Please ask for: Ms Iqraa Malik
Email: iqraa.malik@terraquest.co.uk
Telephone: 01212341390
Our Ref: FG/15/21/PL
Your Ref:
Date: 2nd March 2021

Application for Planning Permission

Development: Conversion of Garage into bedroom & Replace existing conservatory roof to solid roof with Velux
Location: 1 Ferring Grange Gardens Ferring BN12 5HS

PROJECT No.1 , Morton	DRAWING NO. 1467-P001	SCALE 1:1250 @ A3	12	B
ADDRESS No.1 Ferring Grange Gardens	DRAWING TITLE Location & Orientation	DRAWN BY CRE8TIVE LINES - ROZ NOWAK	Feb	2021
ARUN DISTRICT COUNCIL FG/15/21/PL BN12 5HS

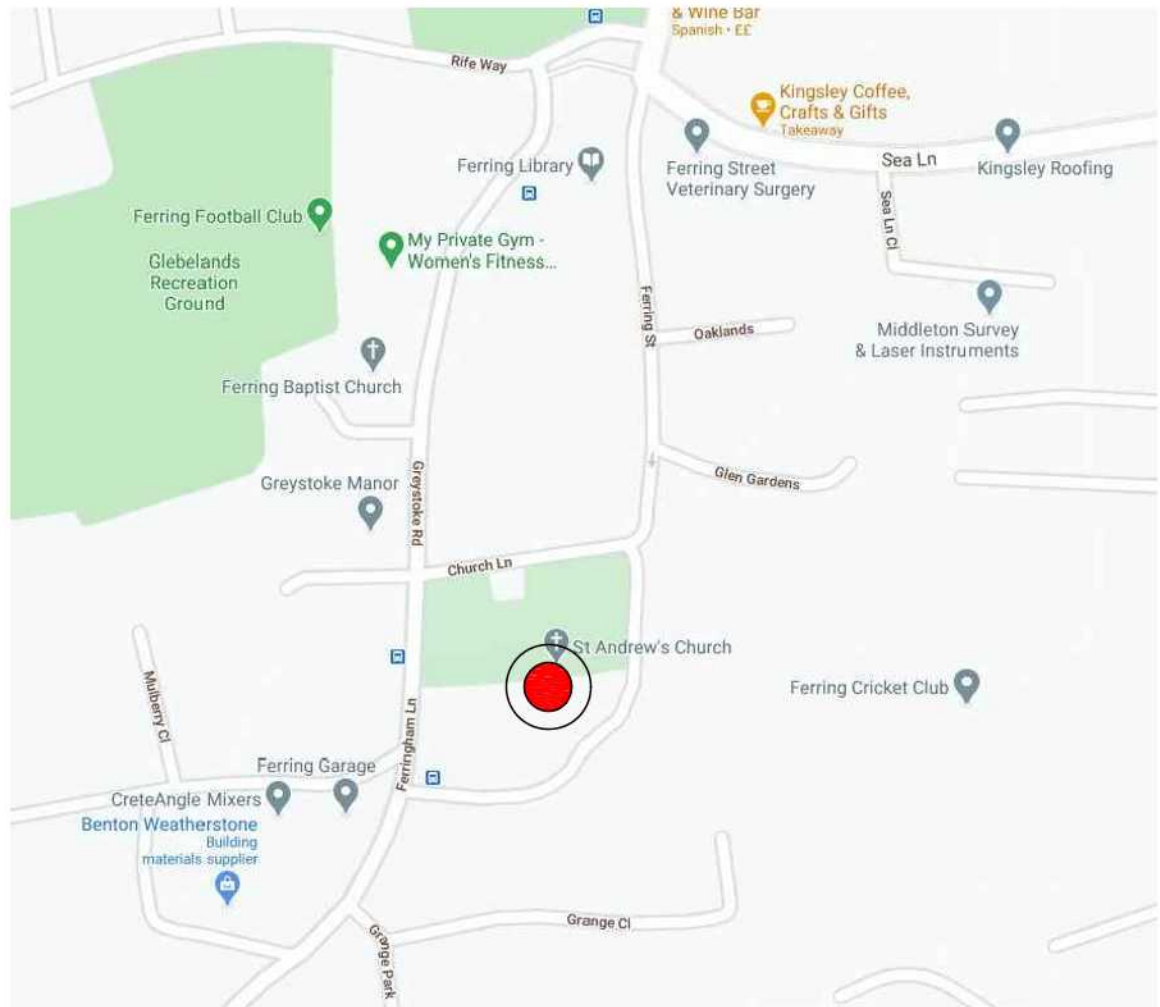
Location Plan: You are required to have a solid red outline around the entire site. Please amend

PROJECT No.1 , Morton	DRAWING NO. 1467-P002	SCALE 1:500 @ A3	12	B
ADDRESS No.1 Ferring Grange Gardens	DRAWING TITLE Existing & Proposed Block Plans	DRAWN BY CRE8TIVE LINES - ROZ NOWAK	Feb	2021

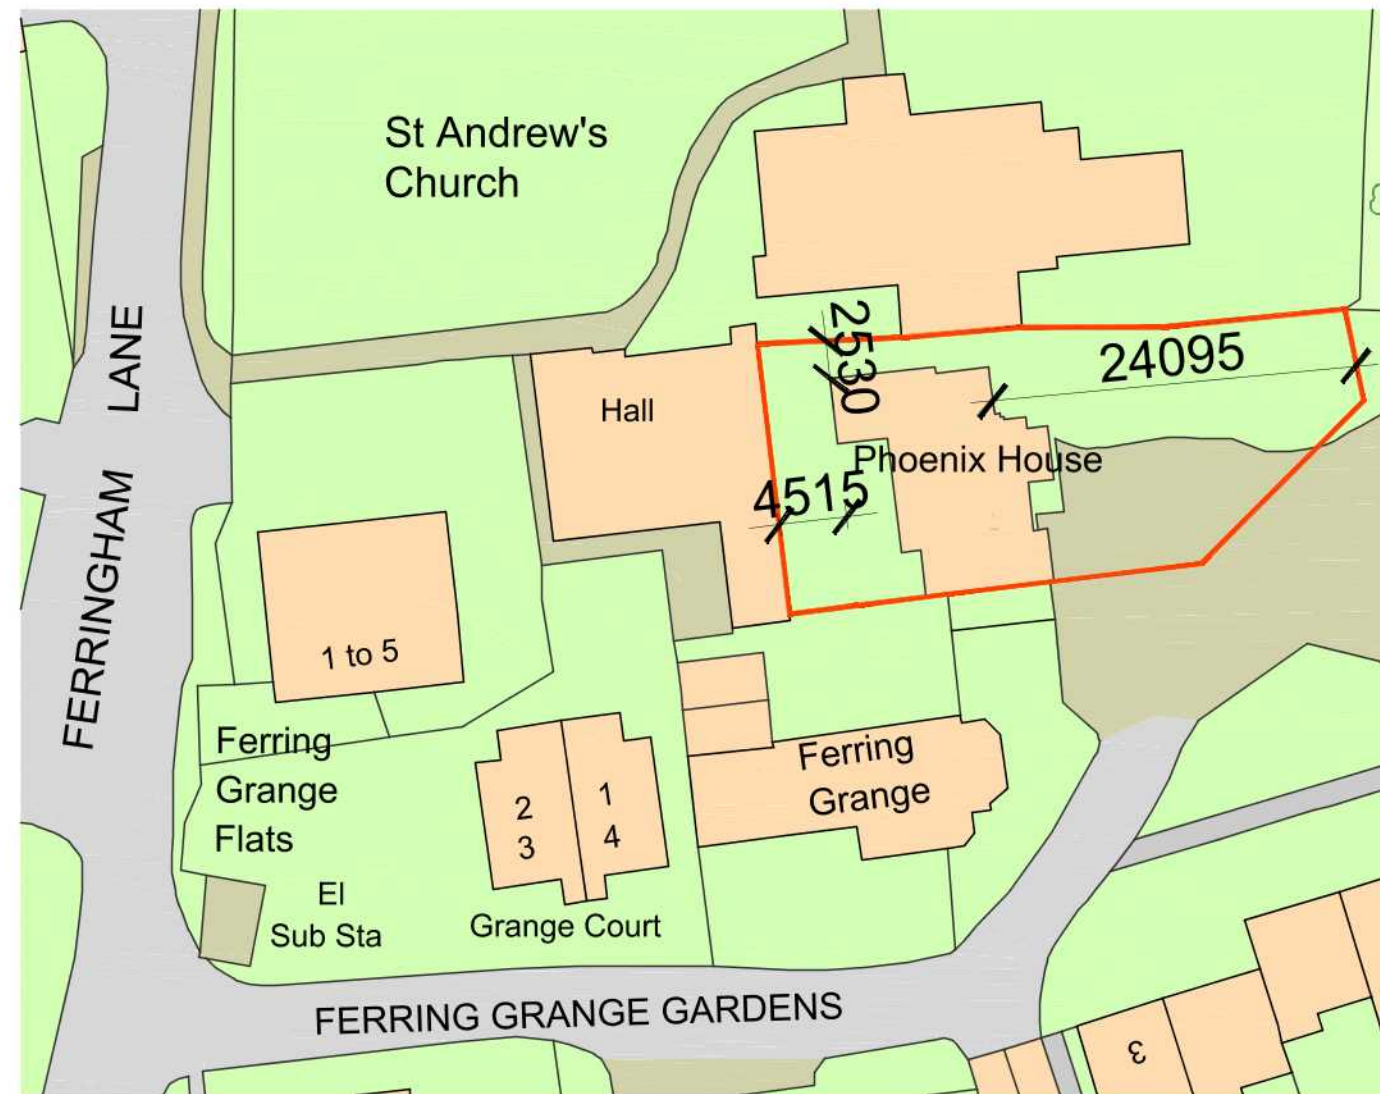
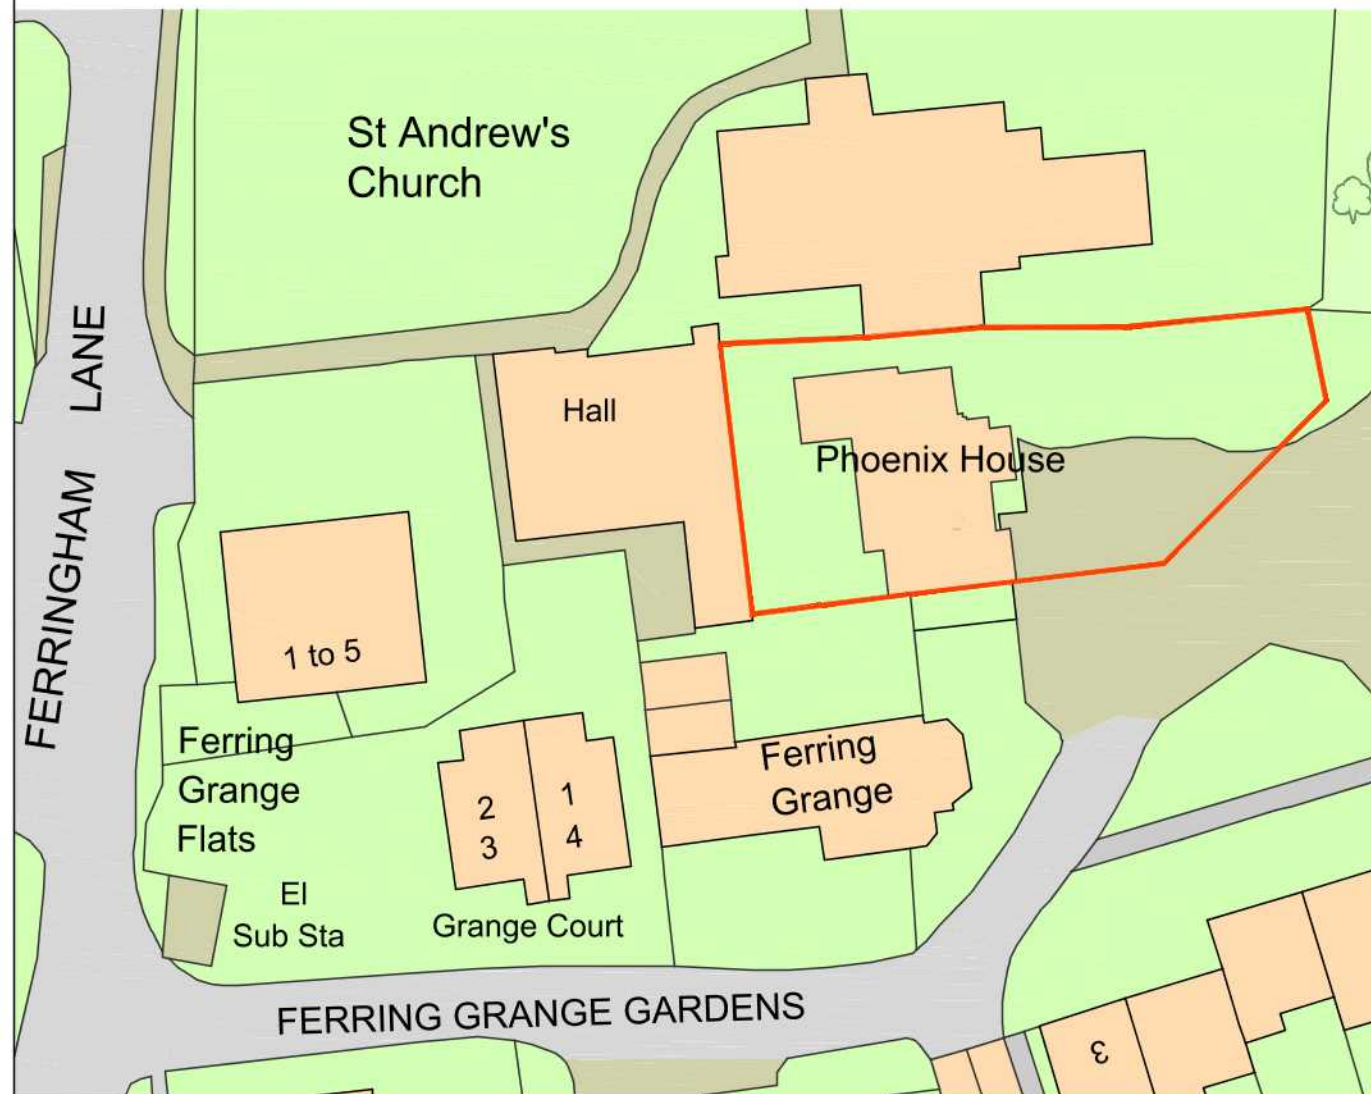
Dimensions: You are required to include dimensions on the block plan from the proposed works to all site boundaries. Please amend
